Final Report - Corrections Required **Application No. PDZD-26-0017**

Description : PDZ Development Plan for the Paint Mines at Reagan Ranch comprised of 102 single-family attached residential lots on 15.283 acres.

Record Type : PDZ Development Plan

Document Filename : Paint Mines at Reagan Ranch PDZ DP_1st Submittal.pdf

LP2.00
13 OF 15

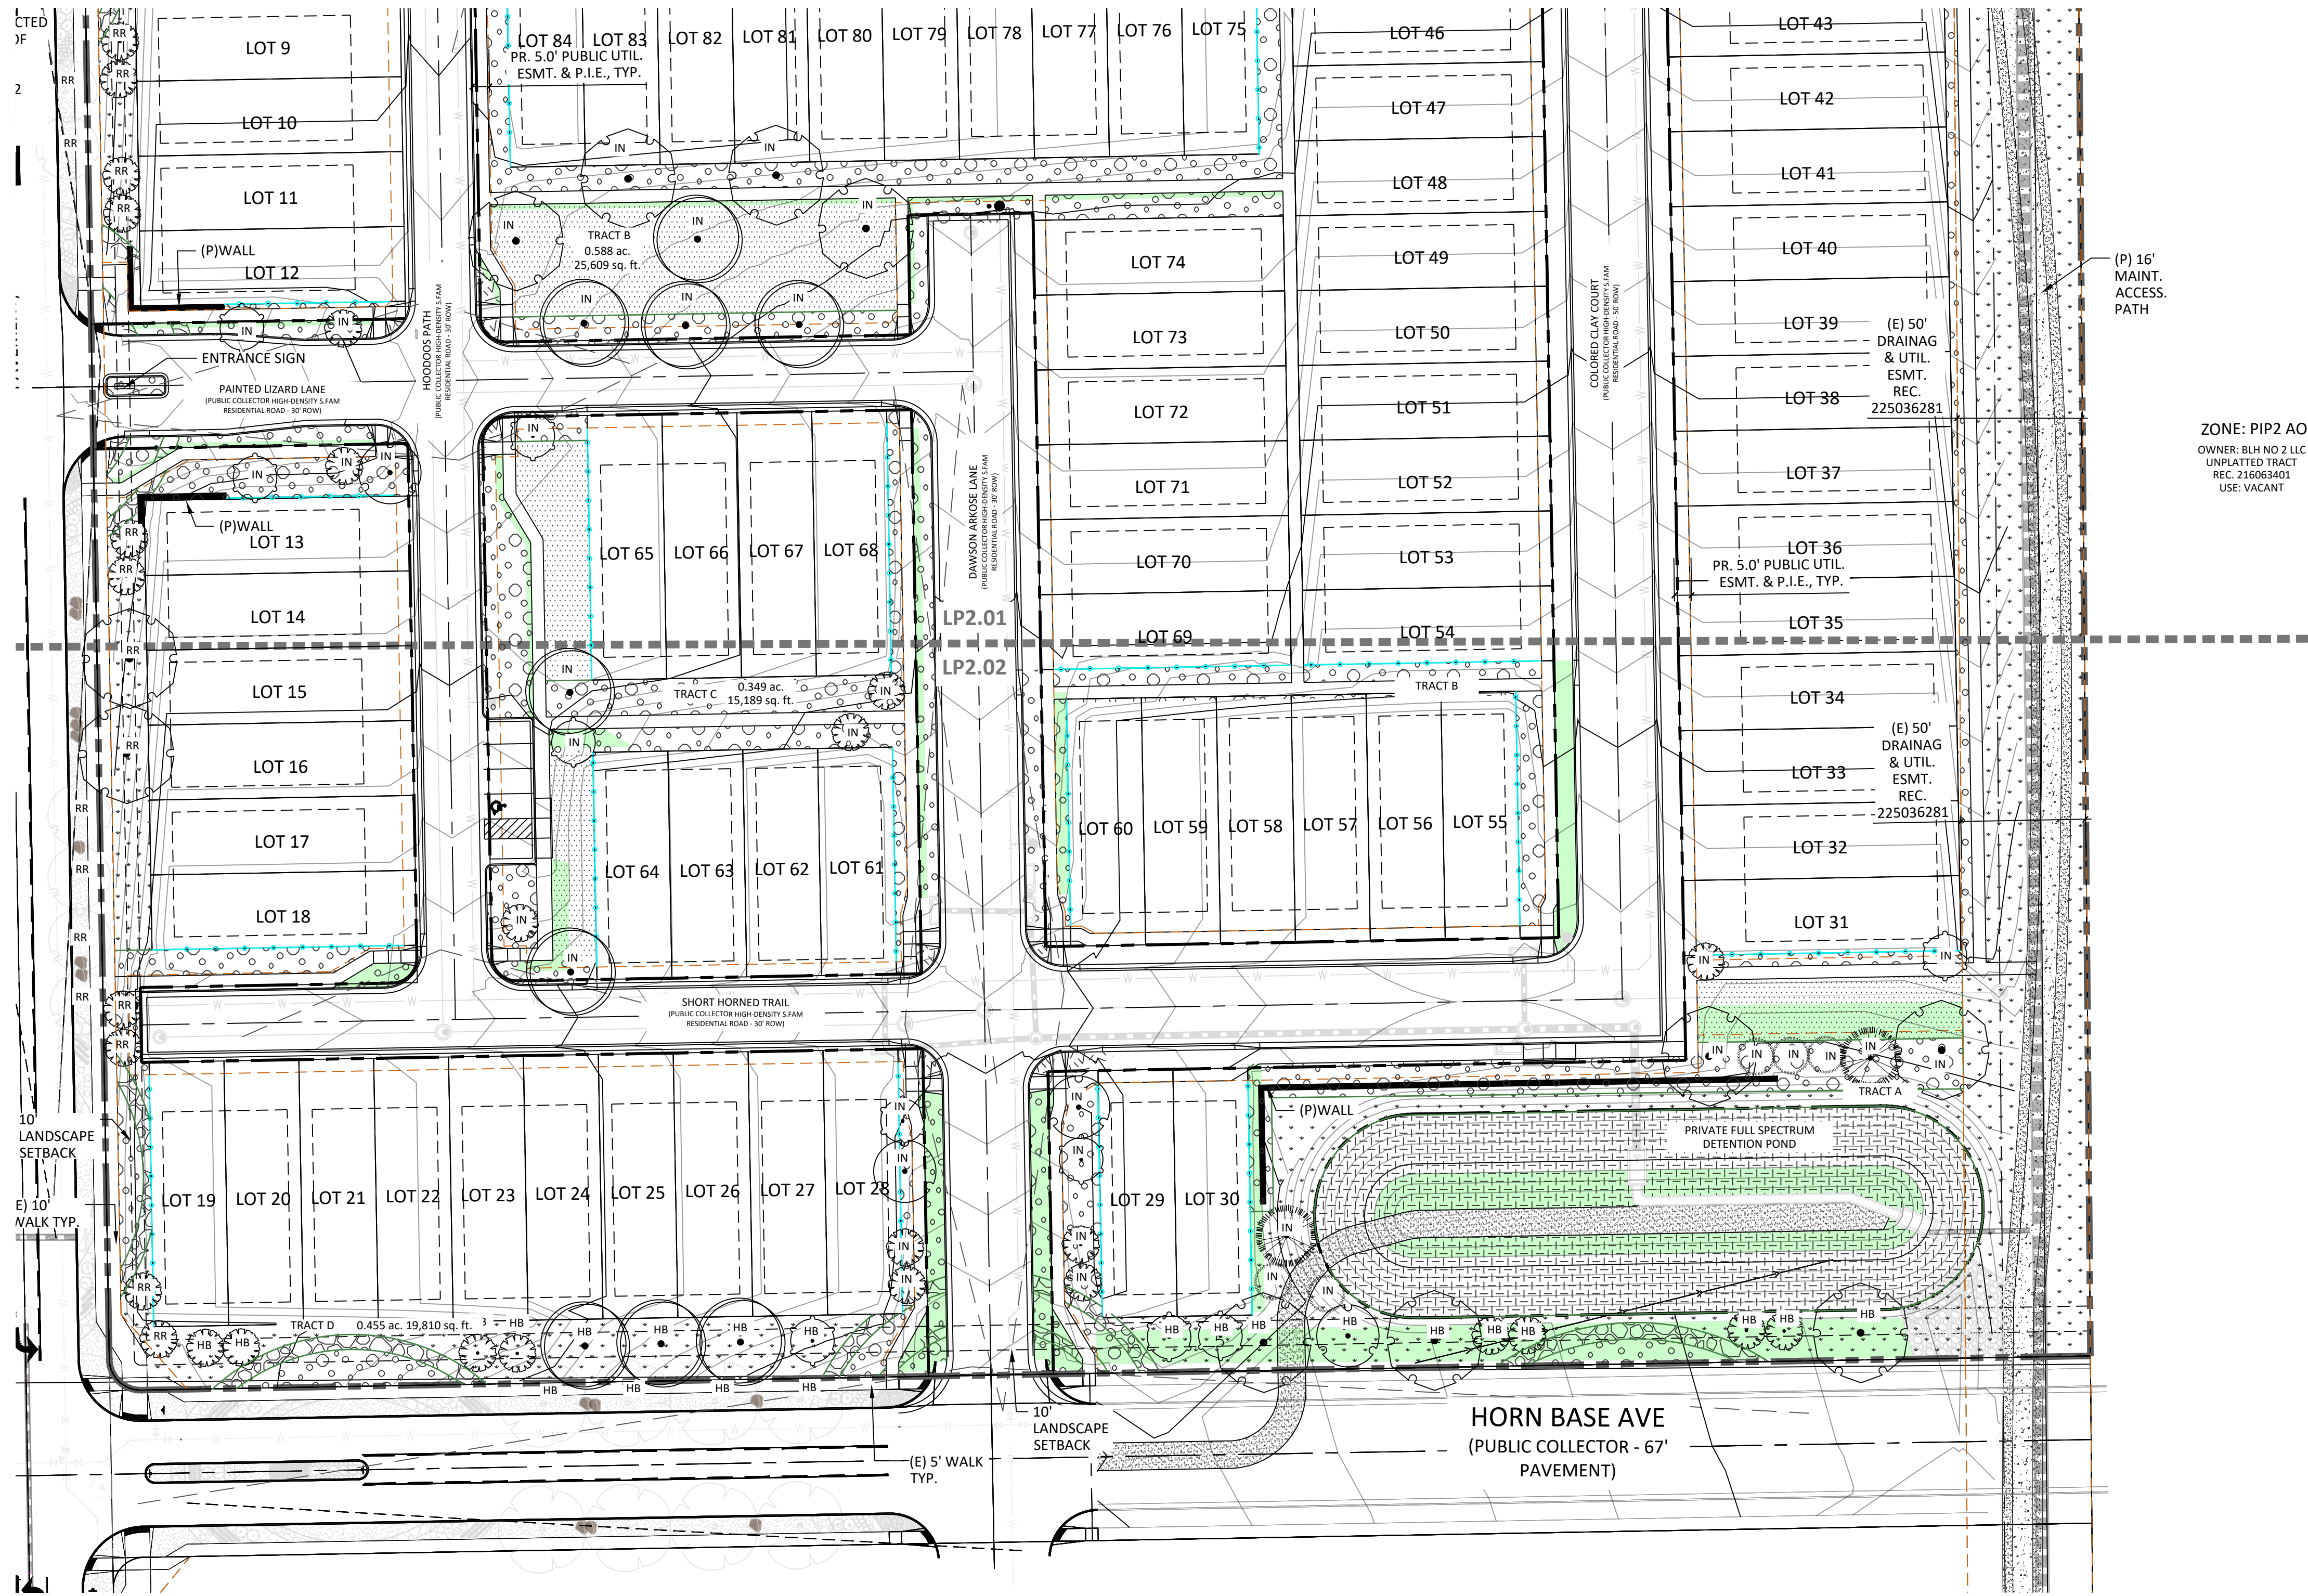
21	14	Gregory Stachon : Planning	Provide site distance triangles at intersections and confirm all shrub plantings are a maximum mature height of 30 inches and that no evergreen trees are within these areas. (FLP Check List #14 and City Traffic Manual)
22	14	Gregory Stachon : Planning	Label the height and material of any proposed fences and walls on the landscape plans.
